WEST SUSSEX COUNTY COUNCIL CONSULTATION

TO:	Arun District Council - FAO: Hannah Kersley
FROM:	WSCC – Highways Authority
DATE:	23 June 2025
LOCATION:	Westholme Nursery Toddington Lane Littlehampton BN17 7PP
SUBJECT:	LU/83/25/OUT Outline planning application (with all matters except access reserved) for the construction of 31 No. residential units. This application is in CIL zone 2 (CIL liable) and may affect the setting of listed buildings.
RECOMMENDATION:	More Information / Modification

ACCESS DIMENSIONS 1:200

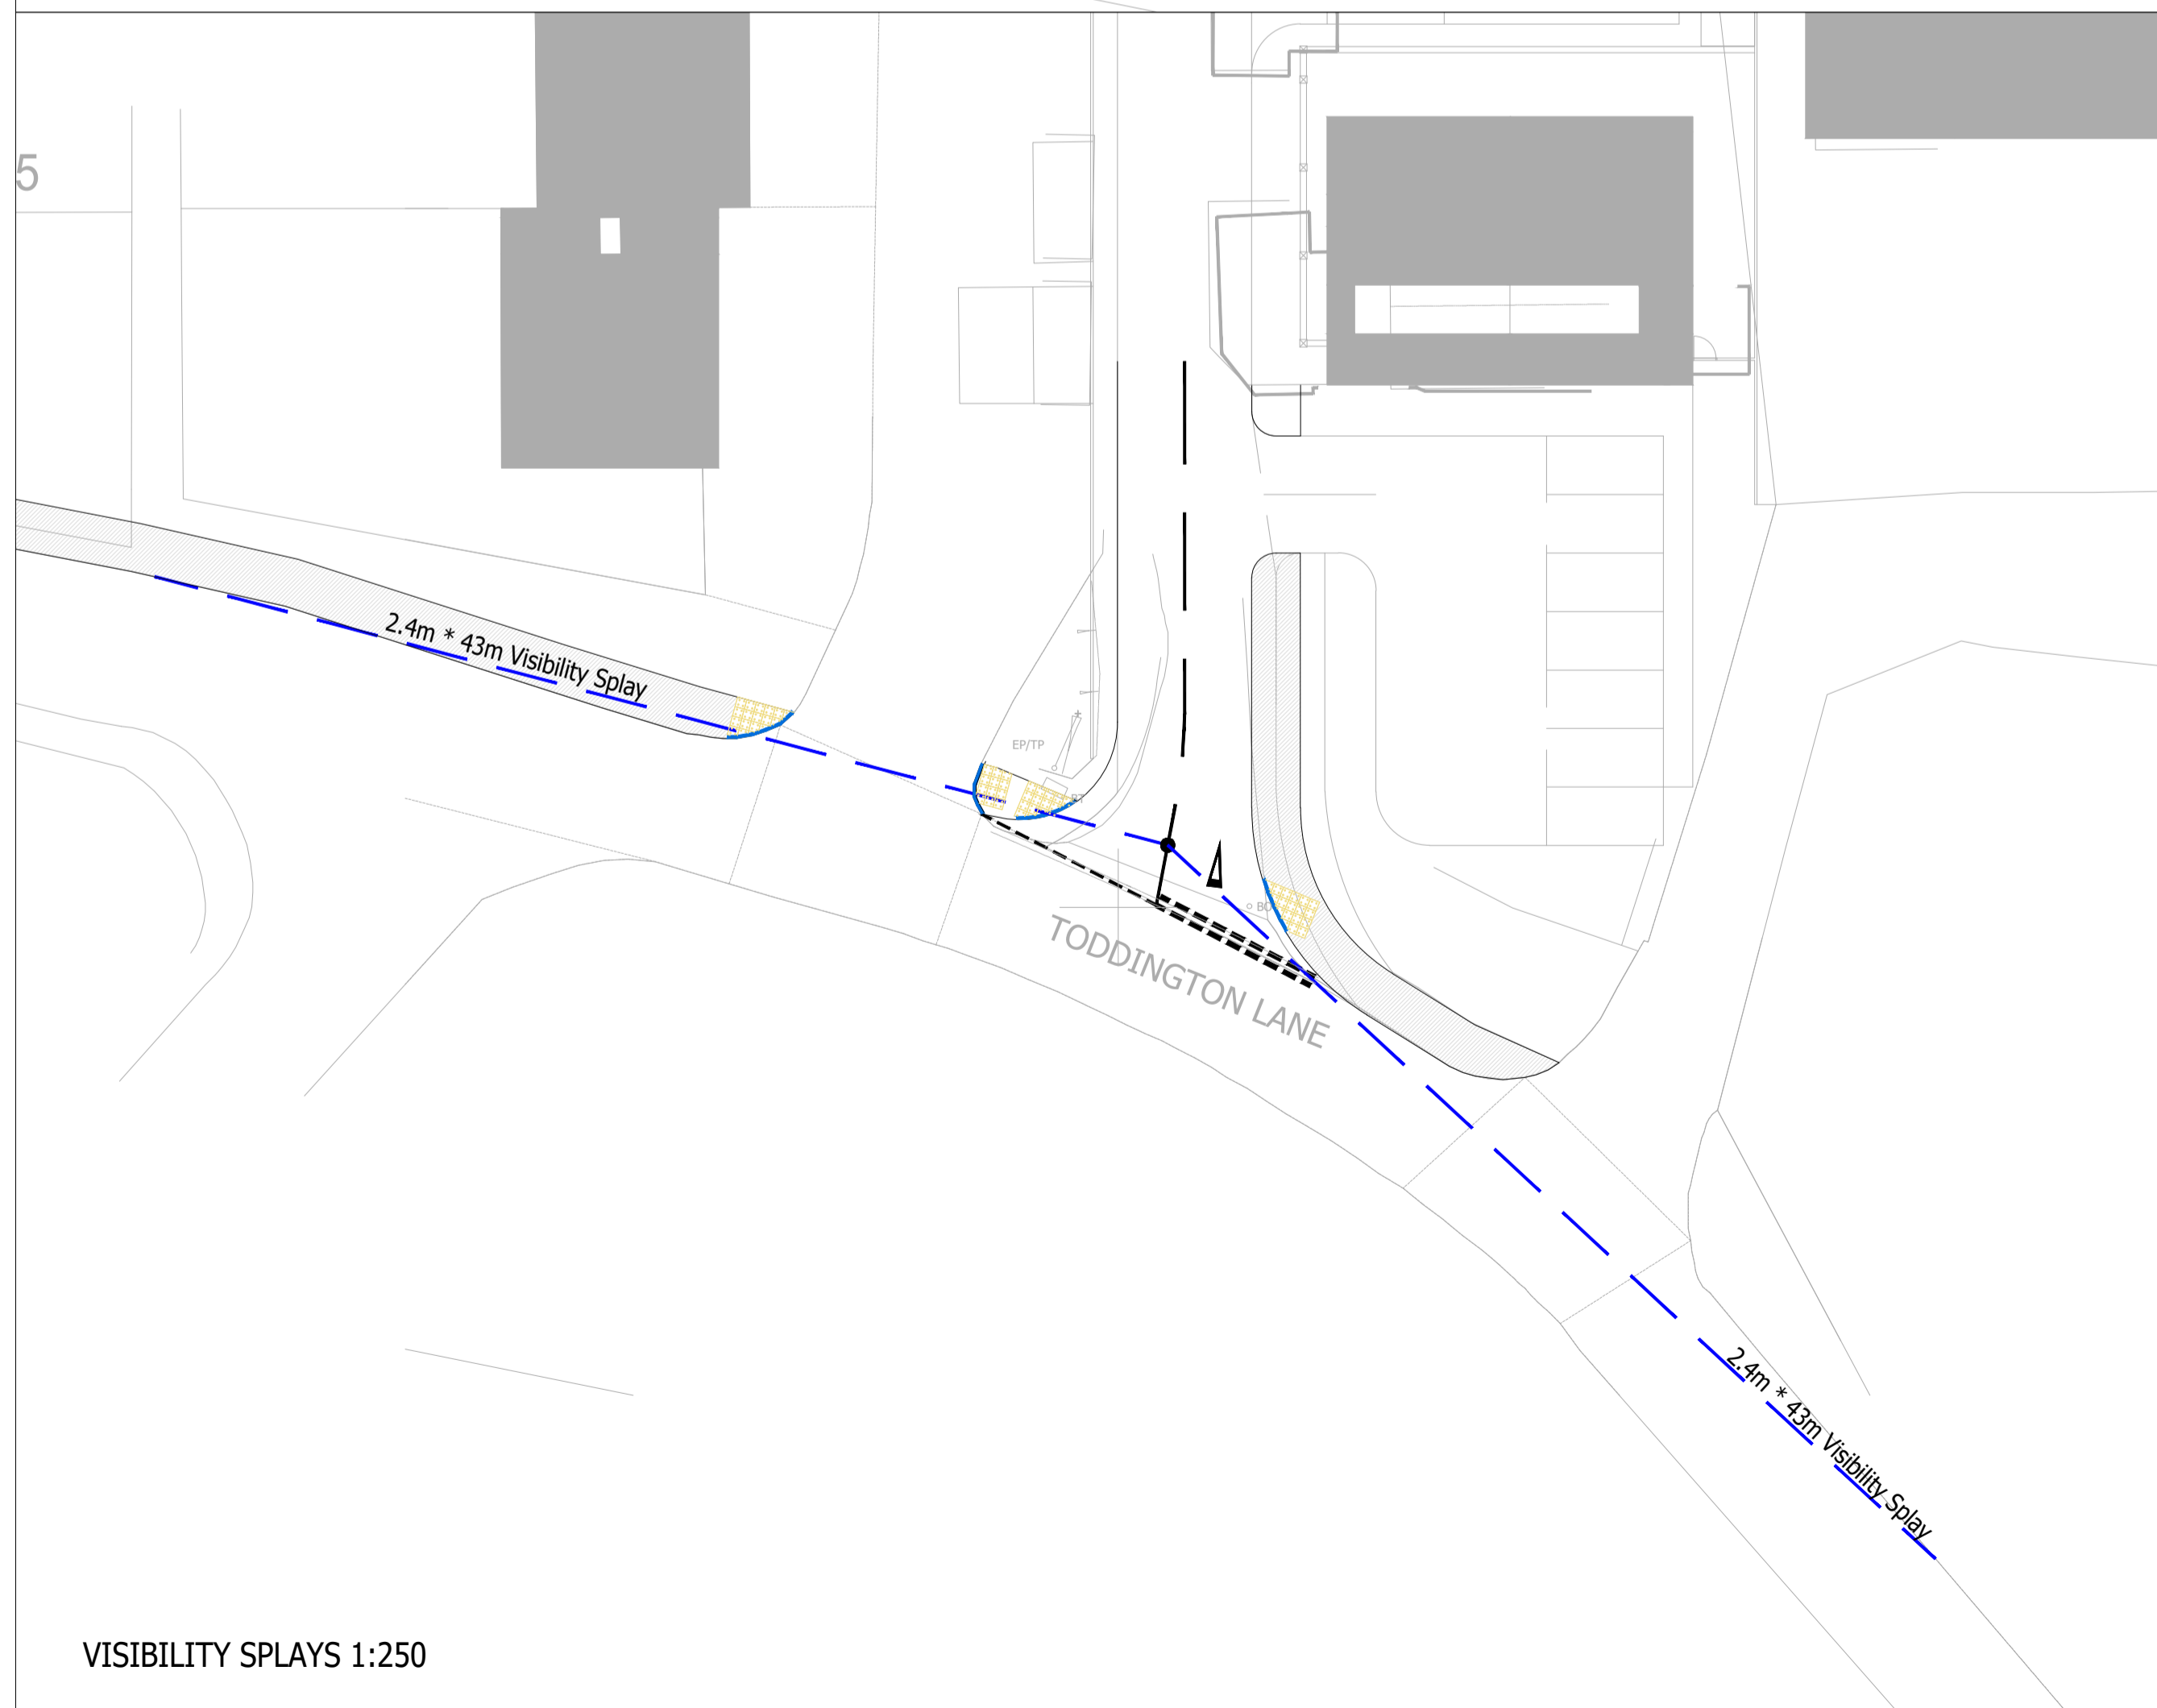
Footway is proposed either side access with 2m wide footway along north side Toddington Lane to link to existing at Trevett Place. Uncontrolled crossing (dropped kerb/tactile paved) to connect to existing footway on south side of Toddington Lane. Plans do not show these crossings in detail. Also advise uncontrolled crossing of site access demonstrated.

- Show the uncontrolled dropped kerb/tactile paved crossing of Toddington Lane and connection in
- Show dropped kerb/tactile paved crossing of site bellmouth access
- Provide Designers Response
